WEST SUSSEX COUNTY COUNCIL CONSULTATION

TO:	Arun District Council FAO: James Cross
FROM:	WSCC - Highway Authority
DATE:	24 November 2021
LOCATION:	Woodgate Centre Oak Tree Lane Chichester PO20 3GU
SUBJECT:	AL/107/21/PL Demolition of the Woodgate Centre buildings (including 3 No. residential dwellings) & the construction of 180 No. residential dwellings with the creation of new vehicular access with footways and cycleways, ancillary road infrastructure, emergency access arrangements, associated parking, public open space, including children's play space, landscape planting, surface water attenuation & drainage & other associated infrastructure. This site is in Cil Zone H SP2, BEW Strategic Site and is not CIL Liable. Additional information received
DATE OF SITE VISIT:	10 th September 2021
RECOMMENDATION:	More Information Required
S106 CONTRIBUTION TOTAL:	£ See below for current breakdown.

This is the second WSCC Highways (CHA) response to the above planning application for demolition of the Woodgate Centre buildings (including 3 No. residential dwellings) and the construction of 180 No. residential dwellings with the creation of new vehicular access with footways and cycleways, an

TYPICAL CENTRAL PIER SECTION
SCALE 1:25

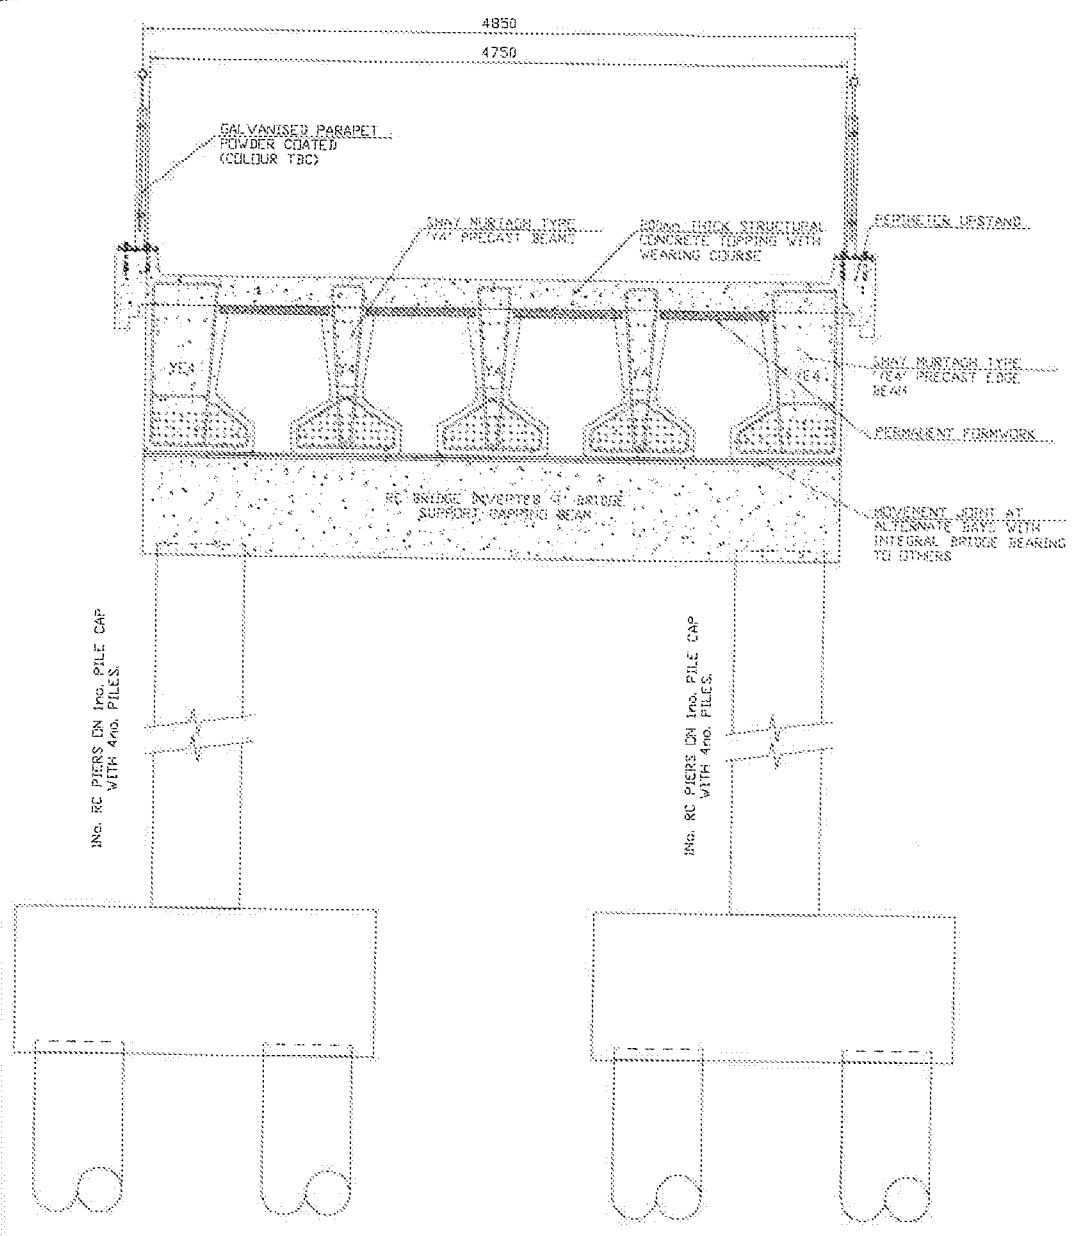
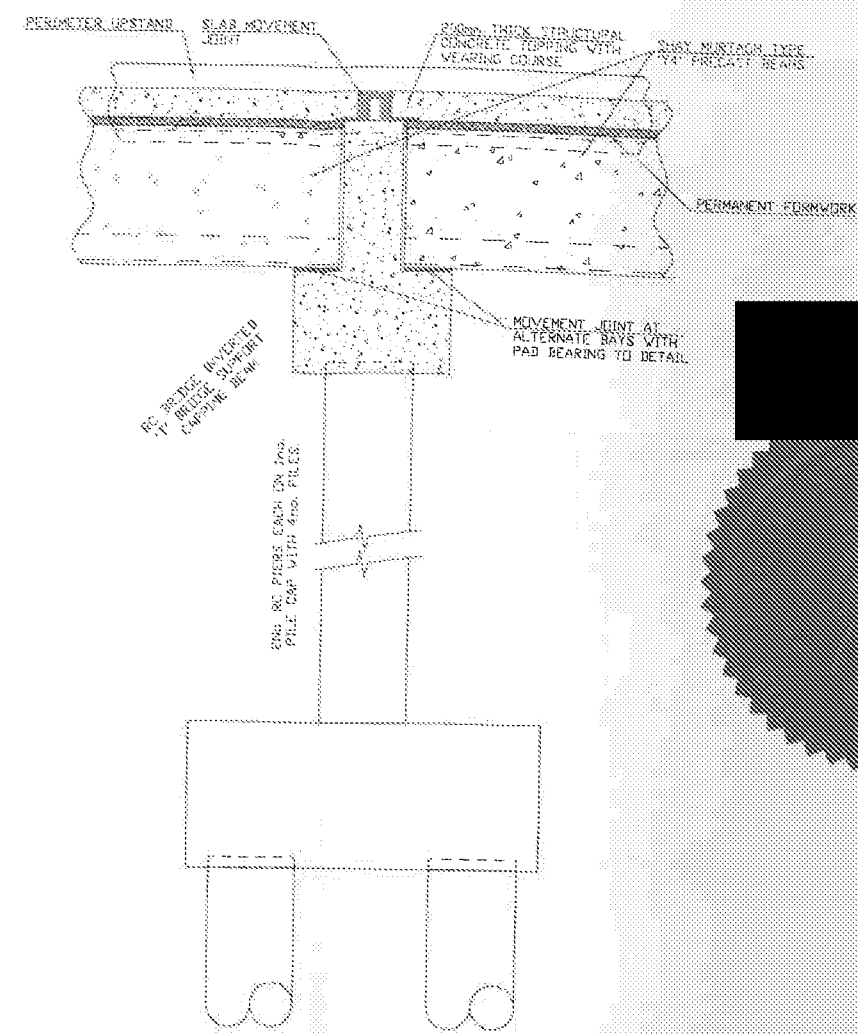
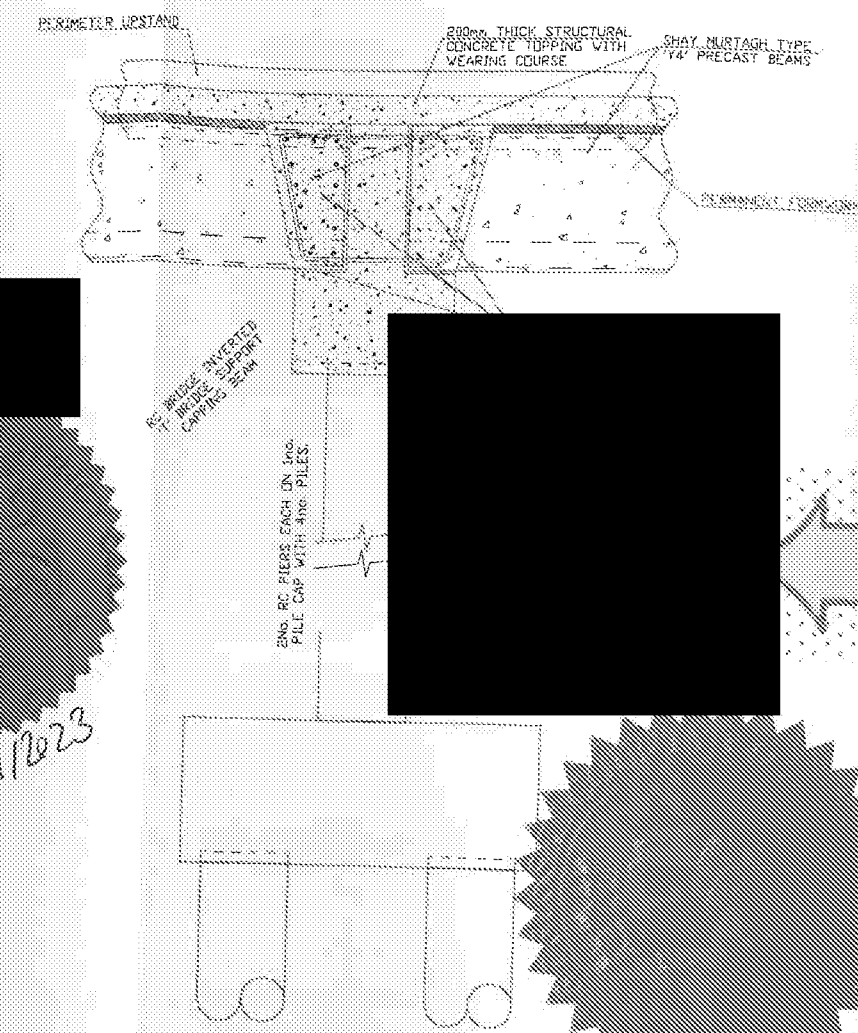
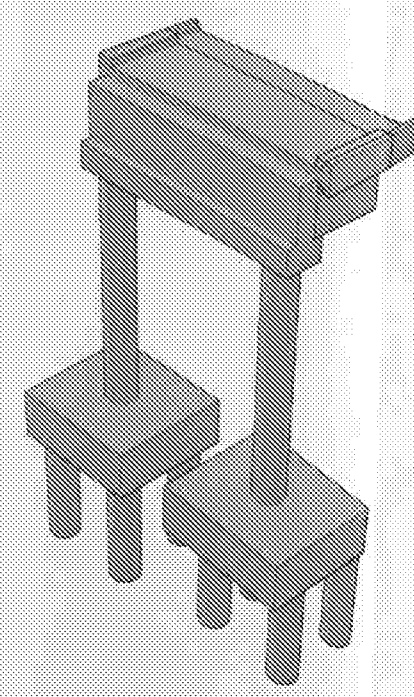
With regard to the E-W link and bridge that would be required, the CHA would

require the developer and/or adjacent developers to construct this at a specified time (likely concurring when developments both sides of the river are at a stage requiring the link). The CHA would not construct it. An appropriate mechanism for securing this and its implementation would need to be included in any S106 Agreement forming part of any planning permission for The Woodgate Centre site. Given the above, it might also require the adjacent developer/s to be party to the S106 Agreement too. For avoidance of doubt, the CHA has not checked the construction details of the bridge - this might be undertaken at the point of submission of detailed plans post-planning or other future date. Therefore, the applicant should not consider that any construction details submitted so far would be acceptable.

The delivery of the pedestrian and cycle bridge across the river will be secured through a S106 agreement with funding being provided by the two developers at each end of the bridge. The works will be undertaken once both developers have gained a suitable planning permission and both developments proceed. Although the S106 is still in draft the following summary is proposed:

- The planning application will set out the safeguarding land which is sufficient to deliver the bridge and any ancillary works that may be required in accordance with an E-W Link Specification Document which includes plans, drawings and costings relating to the E-W Link Works;*
- The Owners covenant with Arun District Council and West Sussex County Council that land to which the East-West Link is to be delivered will be safeguarded for the specific purpose of the bridge and any ancillary works that may be required;*
- The owners shall pay a proportional contribution towards the construction costs of the bridge;*
- The Owner shall permit the County Council, District Council and/or any person nominated by the County Council or the District Council to enter onto the Safeguarded Land for the purposes of carrying out the E-W Link Works.*
